CITY OF ALBUQUERQUE

October 30, 2017

**RE: Taco Bell at Heritage Marketplace
1740 Unser Blvd NW
Request for Permanent C.O. – Not Accepted
Request for 30 Day Temporary C.O. – Accepted
Engineer's Stamp Date: 04/03/17
Engineer's Drainage Certification Stamp Date: 10/26/17
Hydrology File: H09D026**

4 POND 1 OUTLET STRUCTURE DETAIL

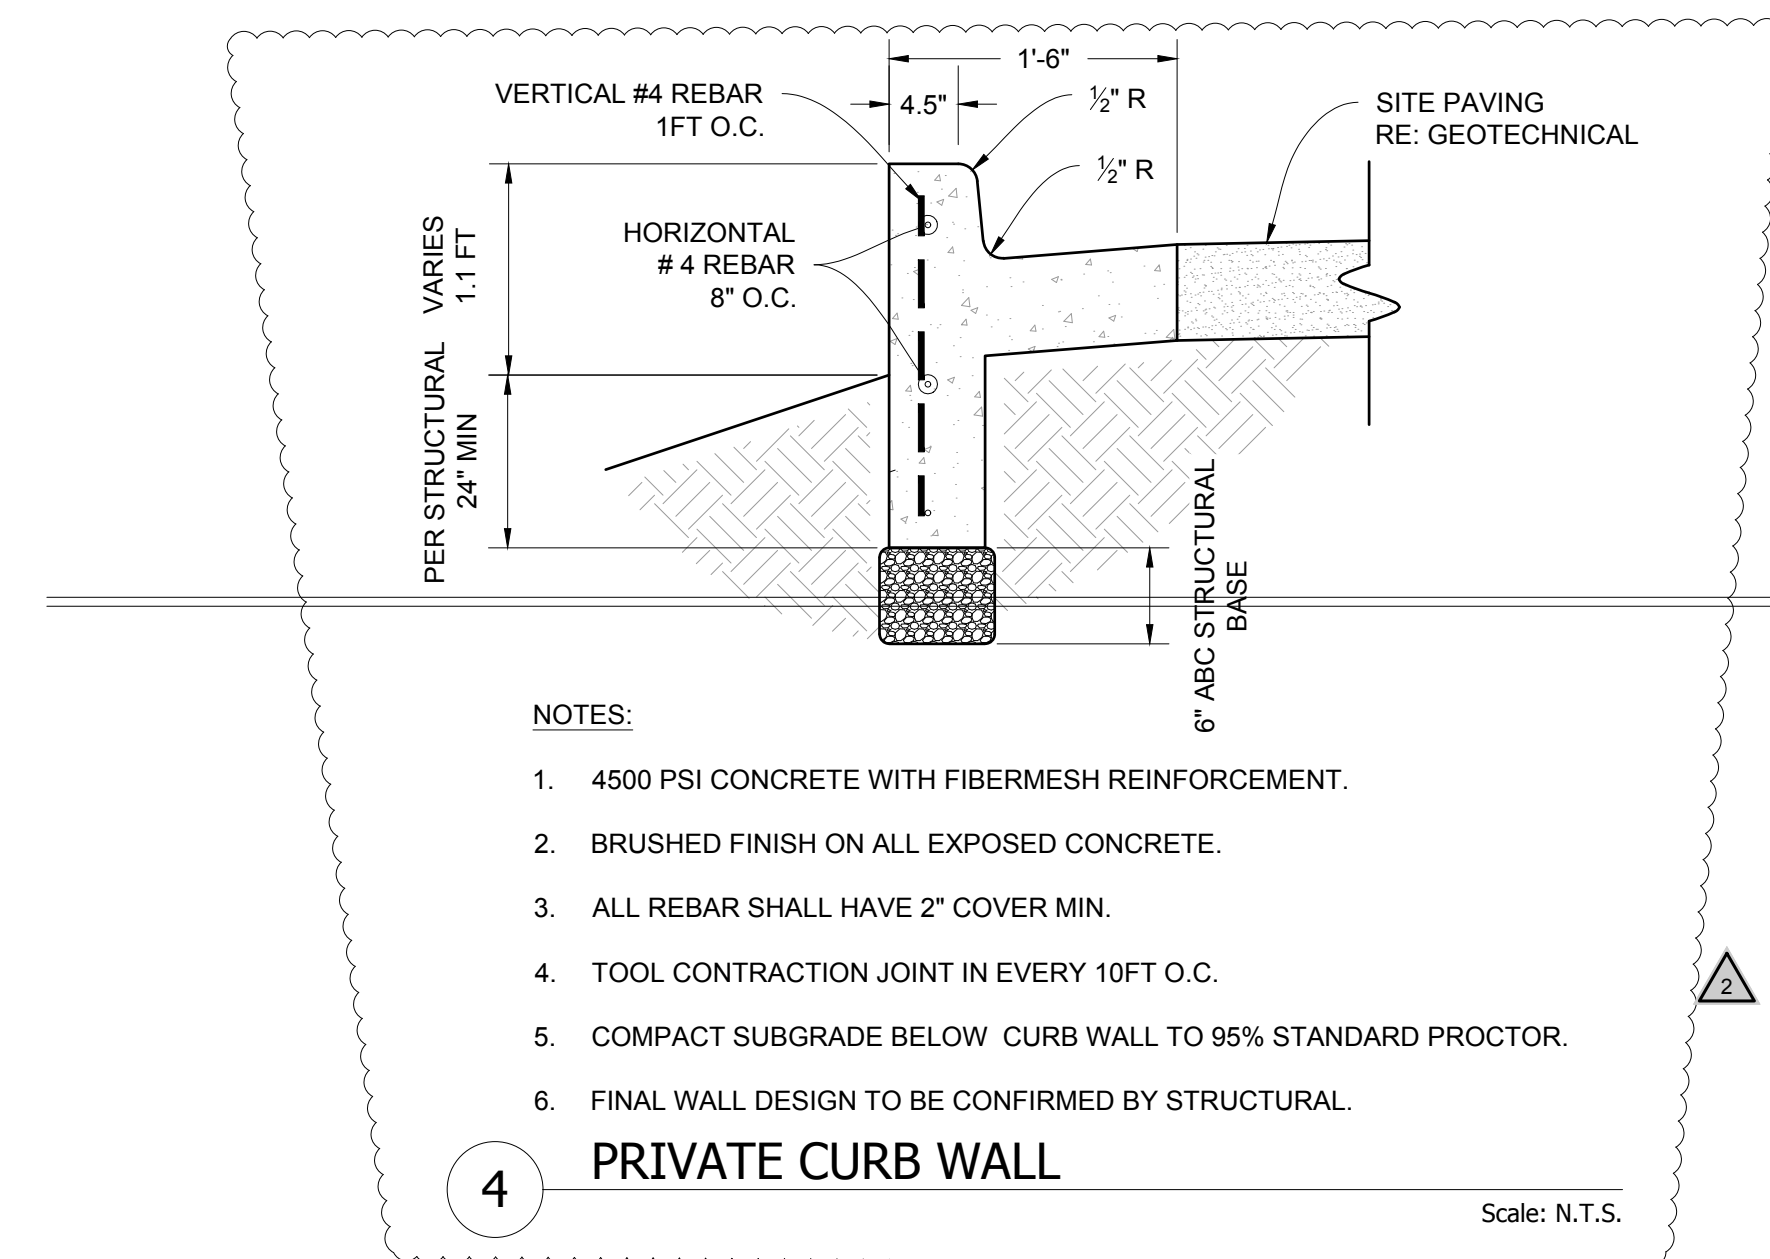
1. The Engineer's Drainage Certification must be placed on the approved Grading and Drainage plans with Engineer's Stamp Date of 3/1/17.
2. The outfall structure in Pond 1 must be fixed to have two orifices as was constructed for the outfall structure in Pond 2 and per the approved Grading and Drainage plans with Engineer's Stamp Date of 3/1/17 and the approved Drainage Calculations dated 2/22/17. See Photos.

Please resubmit for a request for permanent release of Certificate of Occupancy once the outfall structure in Pond 1 is corrected.
